Meadow View
10 Old Mead Road
Lyminster
Littlehampton
West Sussex
BN17 7PU

31st JANUARY 2018

PLANNING APPLICATION LU 386/17/PL.

Site Plan	
Date	November 2017
Scale	1 : 500 @ A3
Sheet	MJS/11-2017/ PL47-02

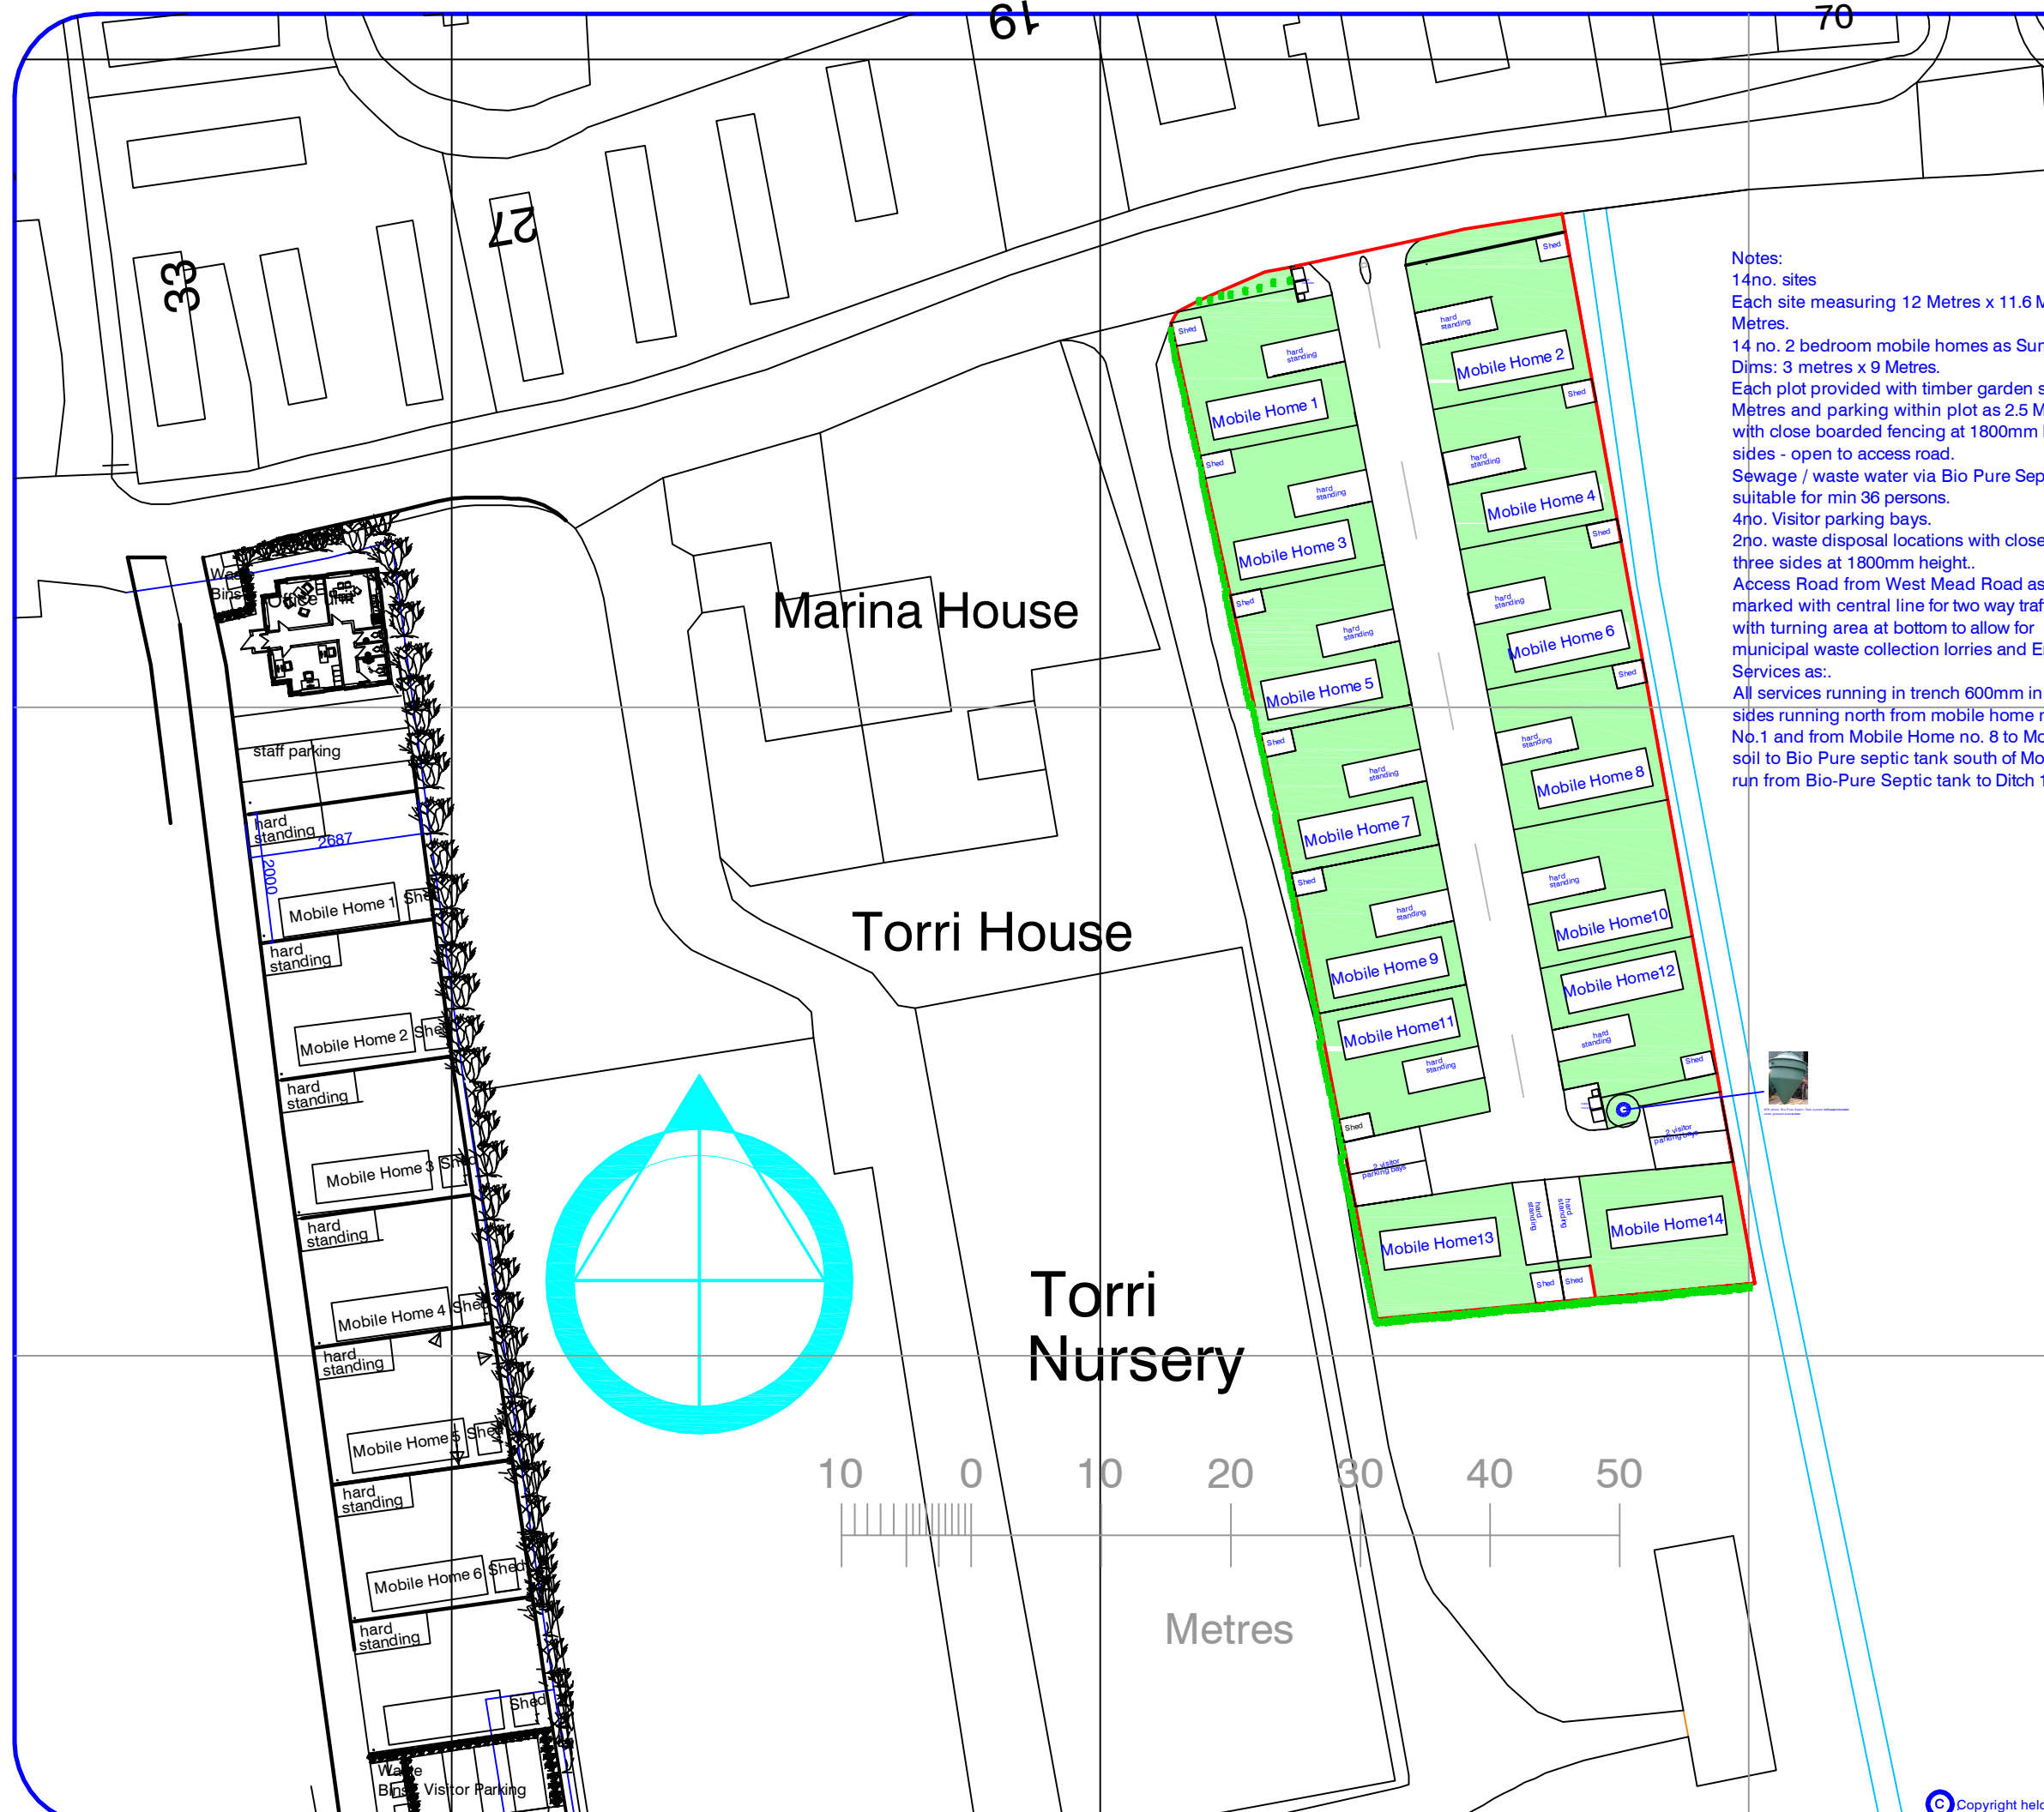
- (1) SEWAGE / WASTE WATER OUTLET (VIA ^{PURE} SEPTIC TANK TREATMENT)
WHAT IS GOING TO HAPPEN TO WATER AFTER ABOVE TANK FILTERS THE WASTE ETC? WHERE IS THE DIVERSITY OF THE WASTE WATER GOING AND DISPOSAL FACILITIES?
THERE ARE NO MAINS OR SEWAGE WASTE FACILITIES ON THAT SITE OR SURROUNDING AREA.
IF PUMPED OUT INTO BLACK DITCH COULD THERE BE RISK OF MAJOR CONTAMINATION / POLLUTION?

- (2) WHAT ABOUT THE WATER TABLES?
- (3) WHAT ABOUT FLOODING? WE ARE A RED ALERT HIGH RISK AREA.
- (4) MAJOR CONCERN - AS THE LAND IS ALMOST ADJACENT TO A FORMER OLD STYLE LANDFILL SITE - WHAT DEPTH WOULD THIS OR THESE TANKS HAVE TO PENETRATE THE LAND TO BE INSTALLED (CONTAMINATION RISK) PLUS ALL THE NECESSARY GROUND WORK FOR PIPE WORK SUPPLYING SERVICES TO EACH OF THE MOBILE HOMES SITED. (14 + 7) = 21 HOMES.
